30 Merrill Street - Updated Traffic Comments

Wed, Sep 21, 2016 at 11:08 AM

Hi Nell – The following represent a status update of my August 29, 2016 preliminary traffic comments.

DRIVEWAY APRON LAYOUT
NOT TO SCALE

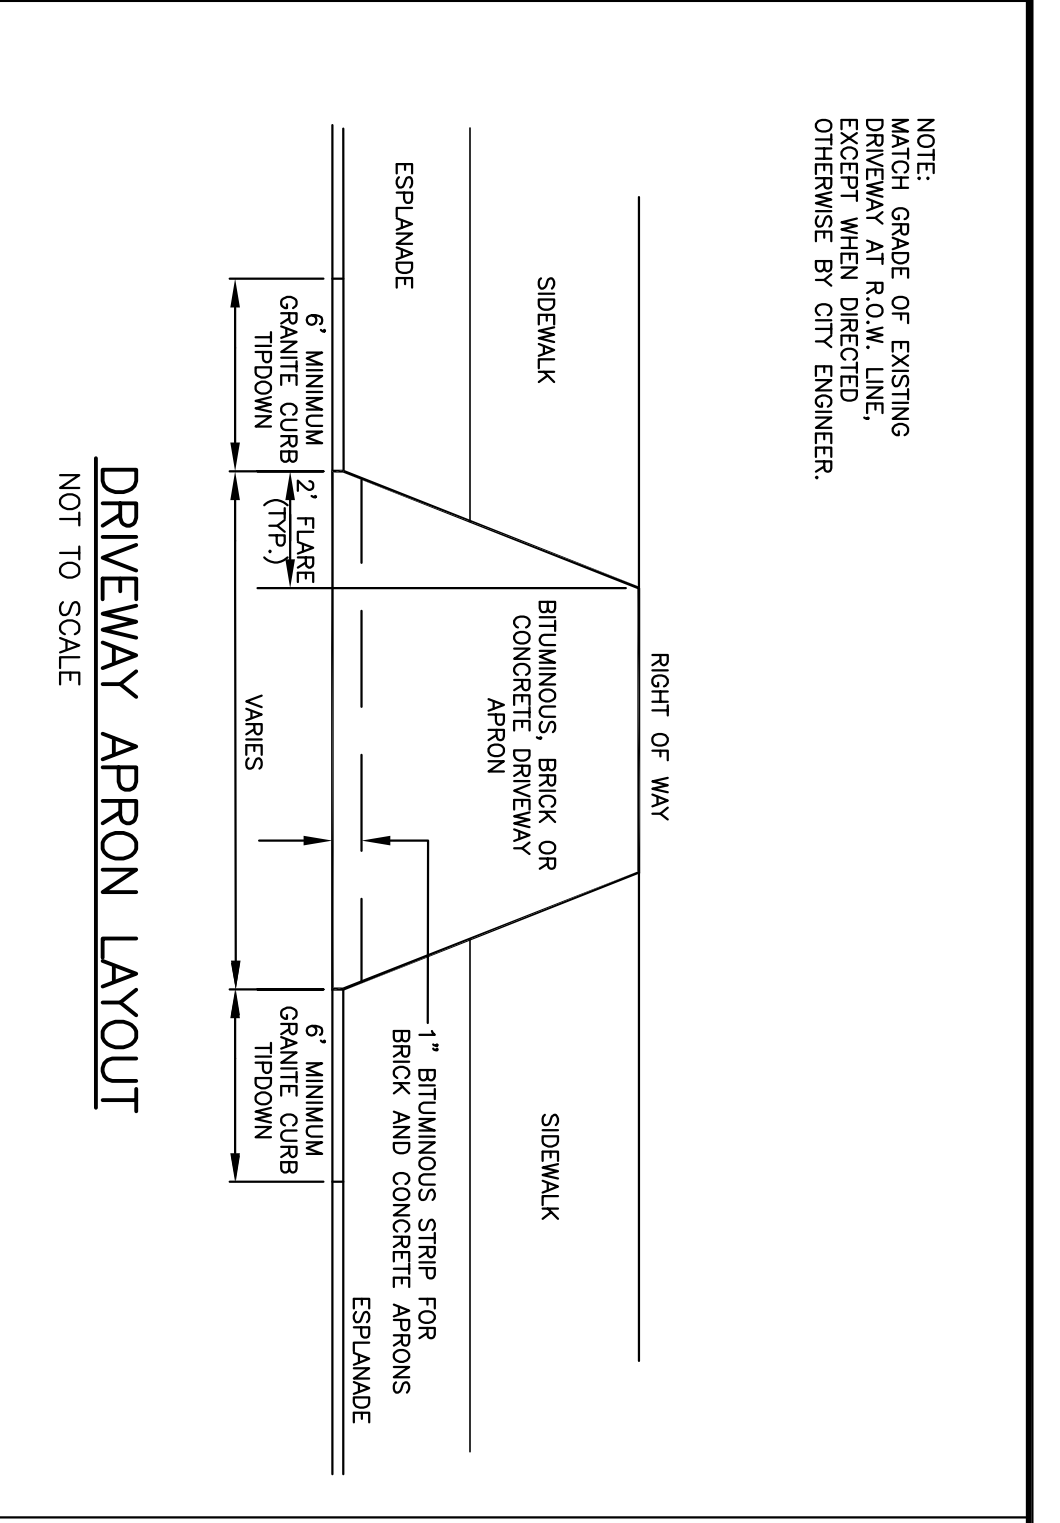
- The site plan depicts the driveway offset from the curb opening, while the existing driveway is centered. The applicant should note why an offset condition is proposed.

Status: Based upon the condition of both tip-down curbing and the driveway apron, the applicant shall center and renovate the driveway apron to meet City standards.

PROJECT NAME: SIX-UNIT BUILDING 30 MERRILL STREET
 PORTLAND, MAINE
 SHEET NAME: SITE LAYOUT PLAN

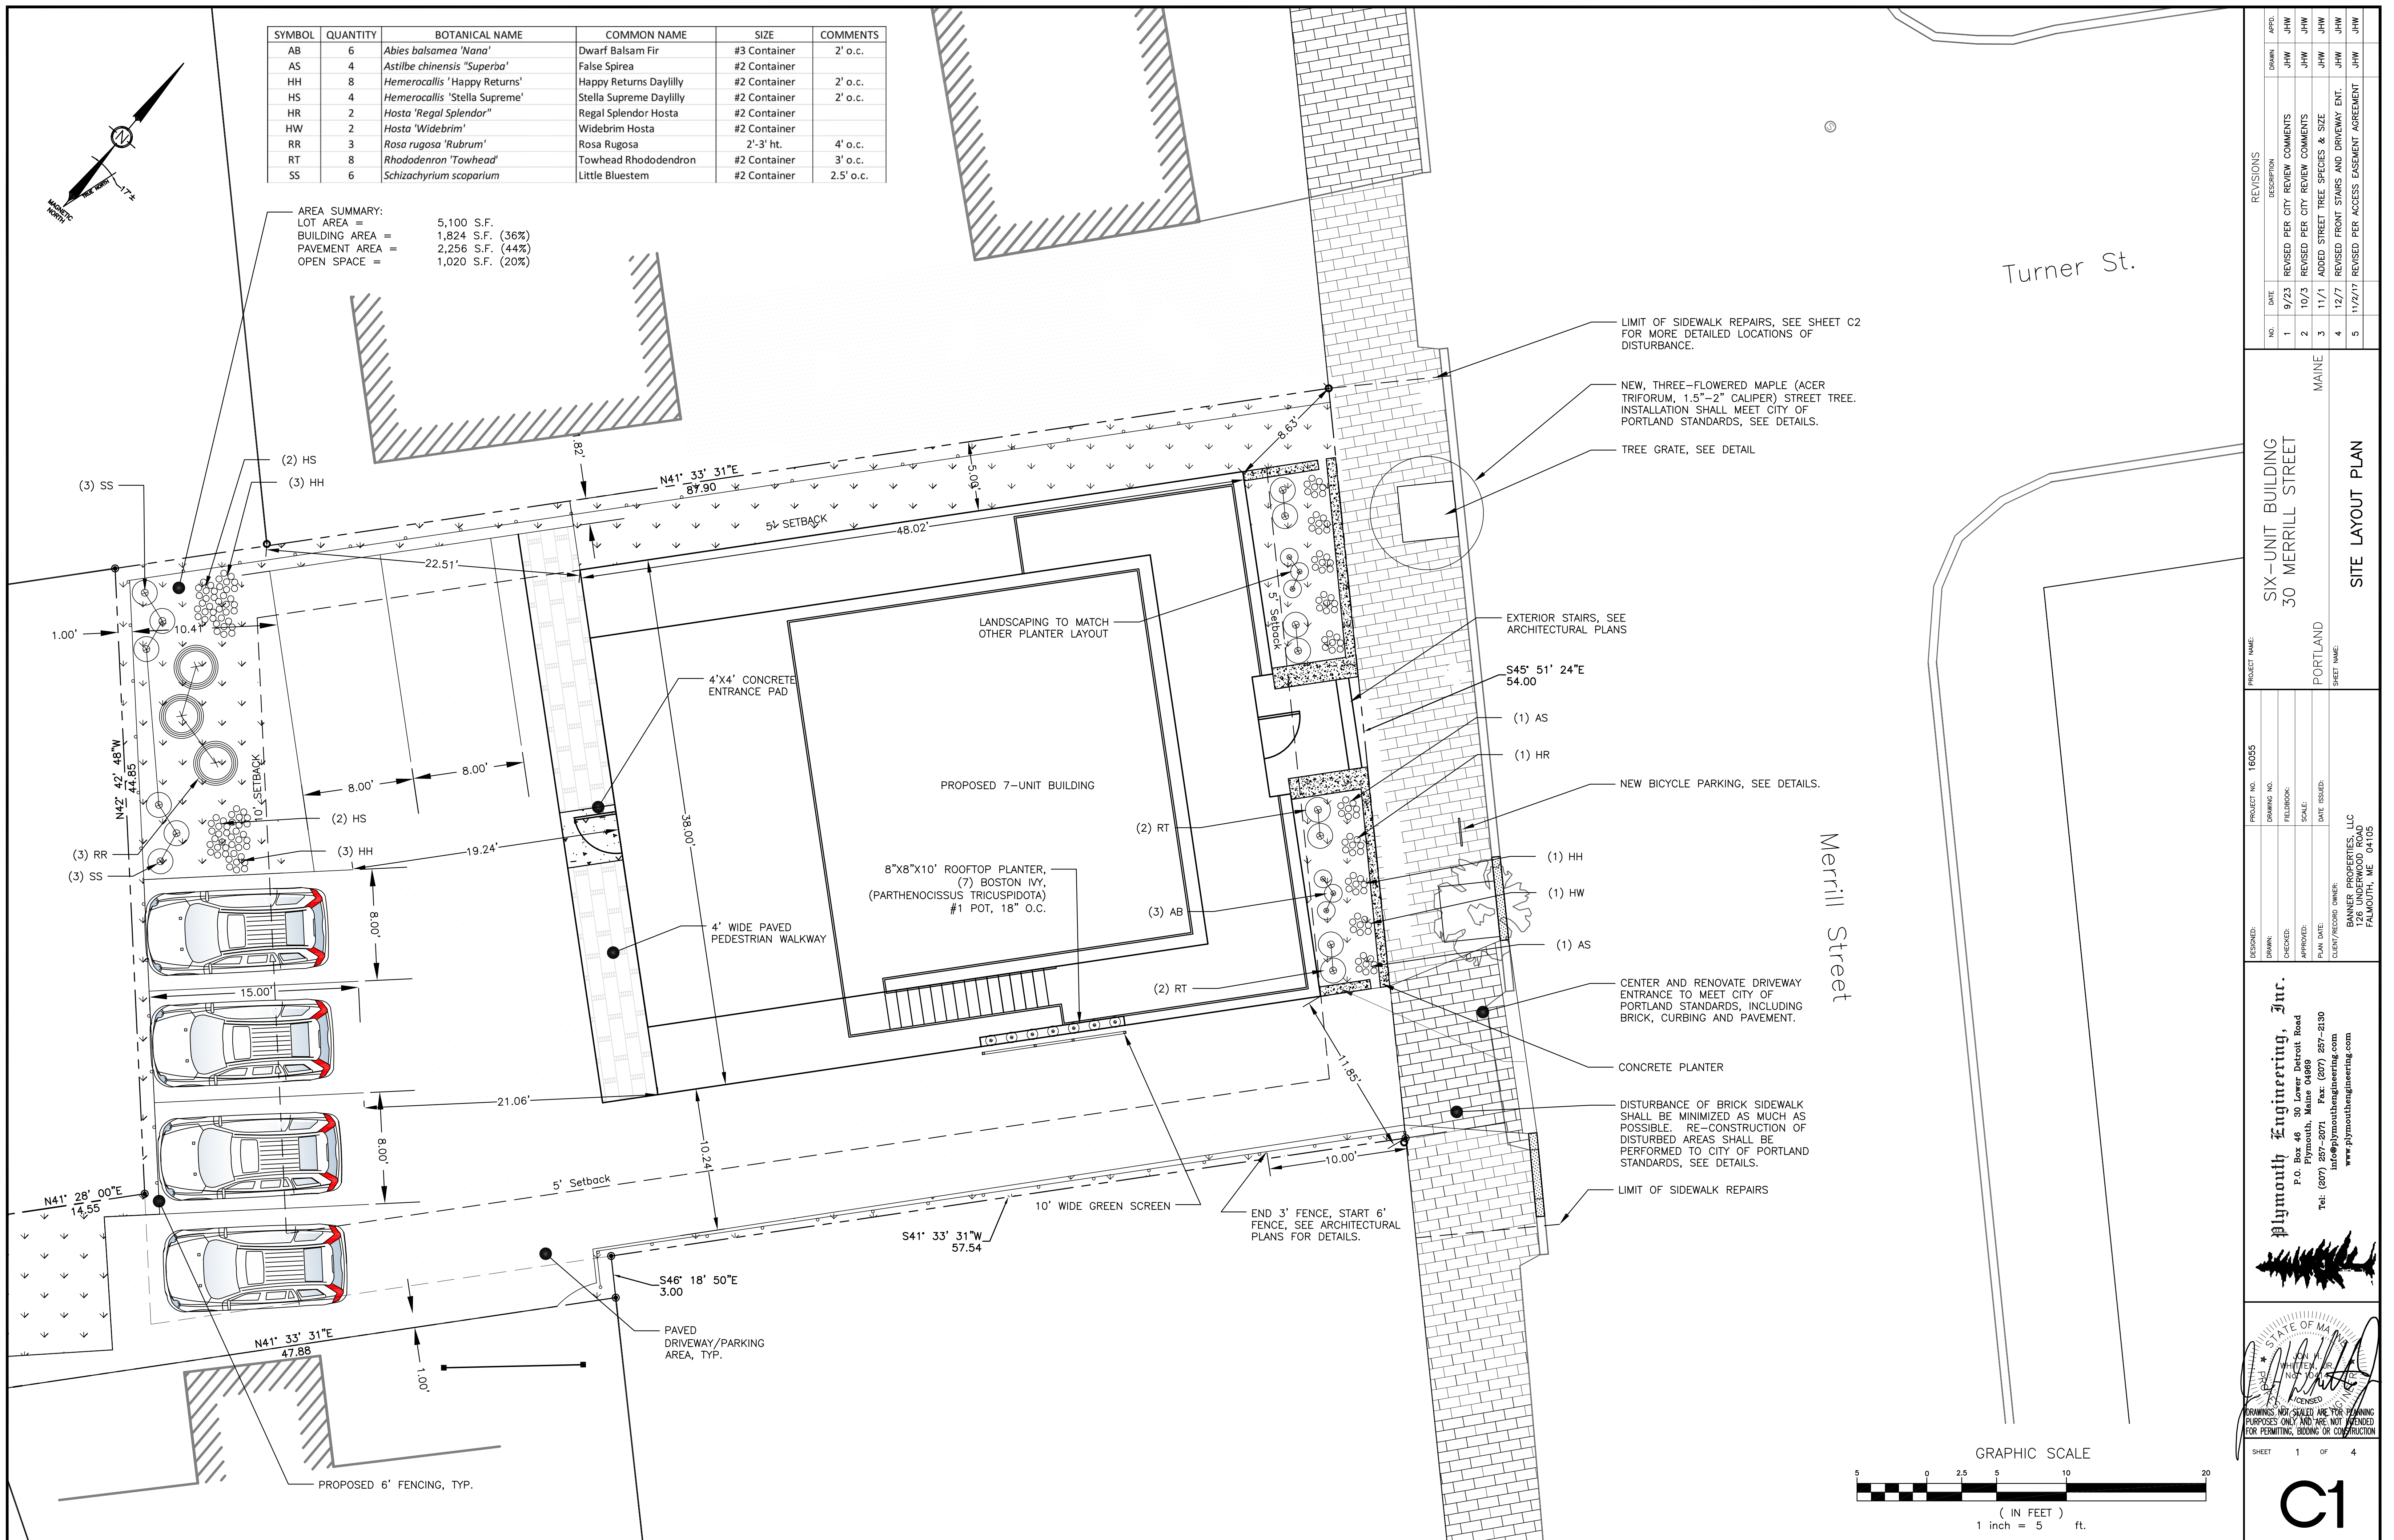
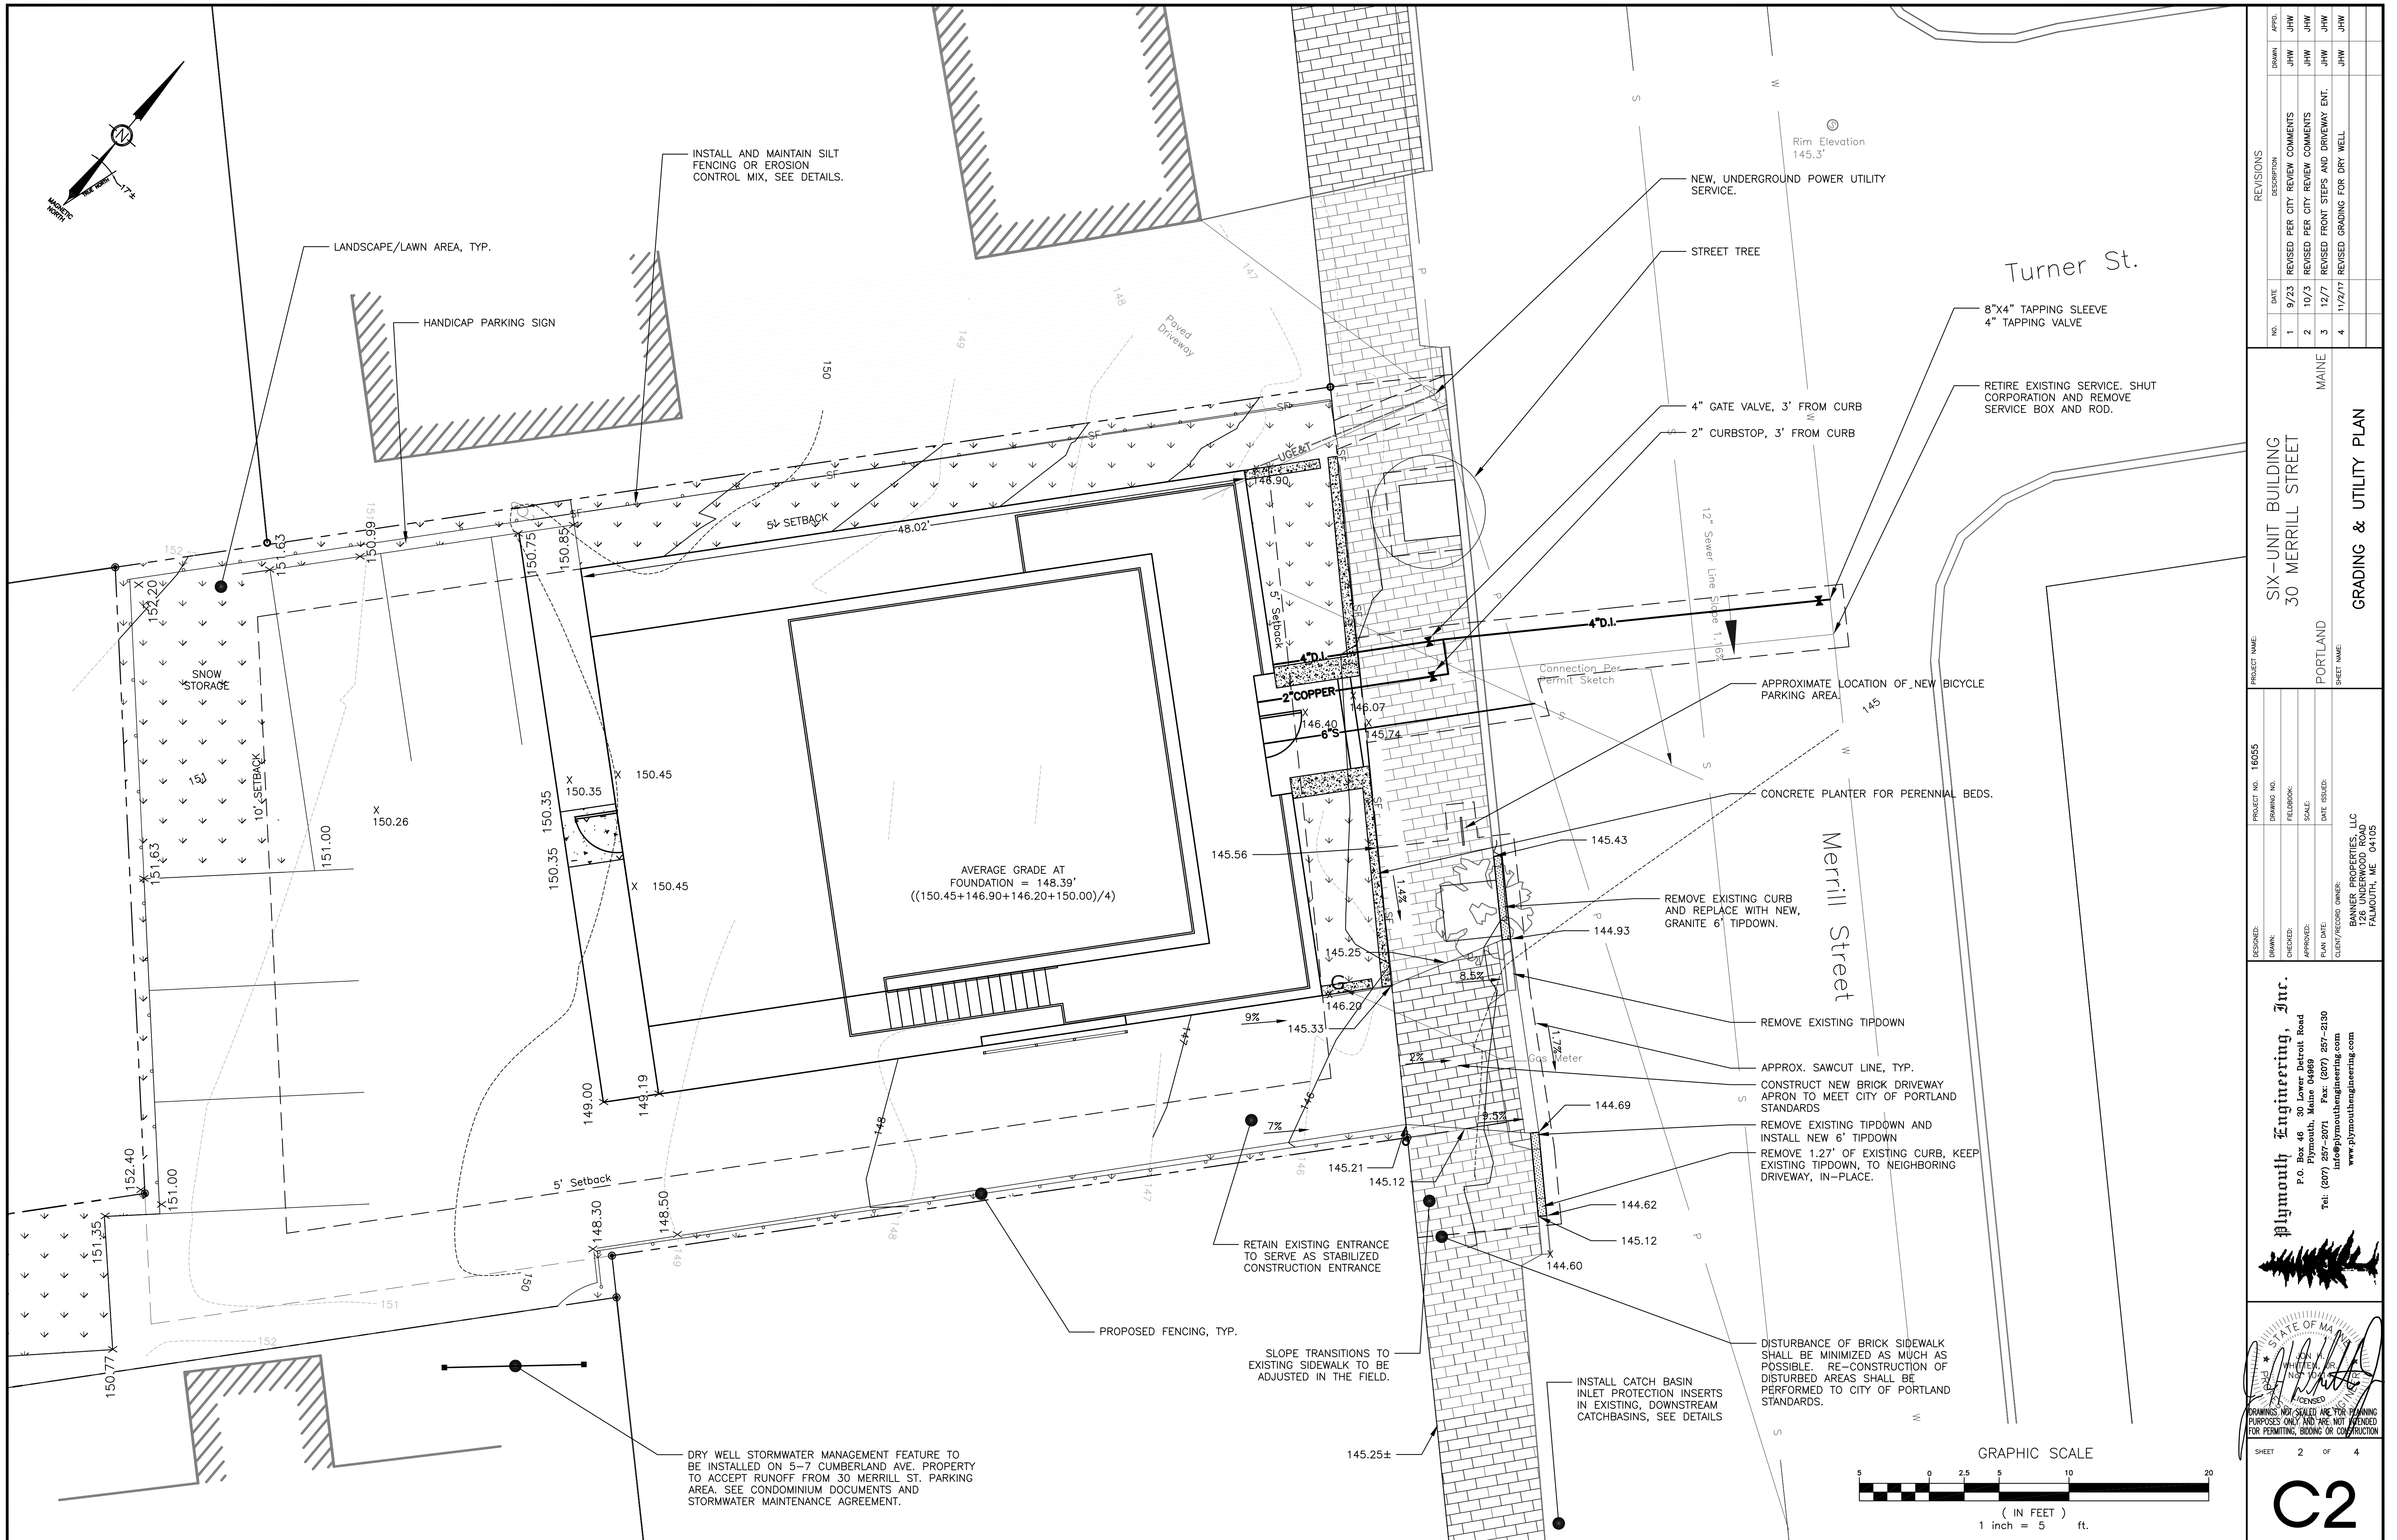
- Access and egress movements from parking spaces will be constrained. The applicant has provided vehicle turning templates that seem to illustrate parking space accessibility is feasible. Given the constrained conditions, I would suggest the applicant simulate the layout in a field test to be reviewed by me. I would note that the parking space adjacent to the handicap space will be difficult to maneuver into and out of.

Status: The applicant has provided vehicle turning template graphics that illustrate movements. Given tight circulation conditions, conflicts with pedestrians entering the building via the driveway and parking lot, I would suggest that the parking lot be designed to minimize conflicts. I would suggest that the parking space adjacent to the handicap parking space be eliminated and used for enhanced circulation space (While I do not oppose backing maneuvers onto Merrill Street, I would prefer that they are minimized). In my professional opinion the site will function adequately by removing the subject space and the previously noted field simulation would no longer be required.
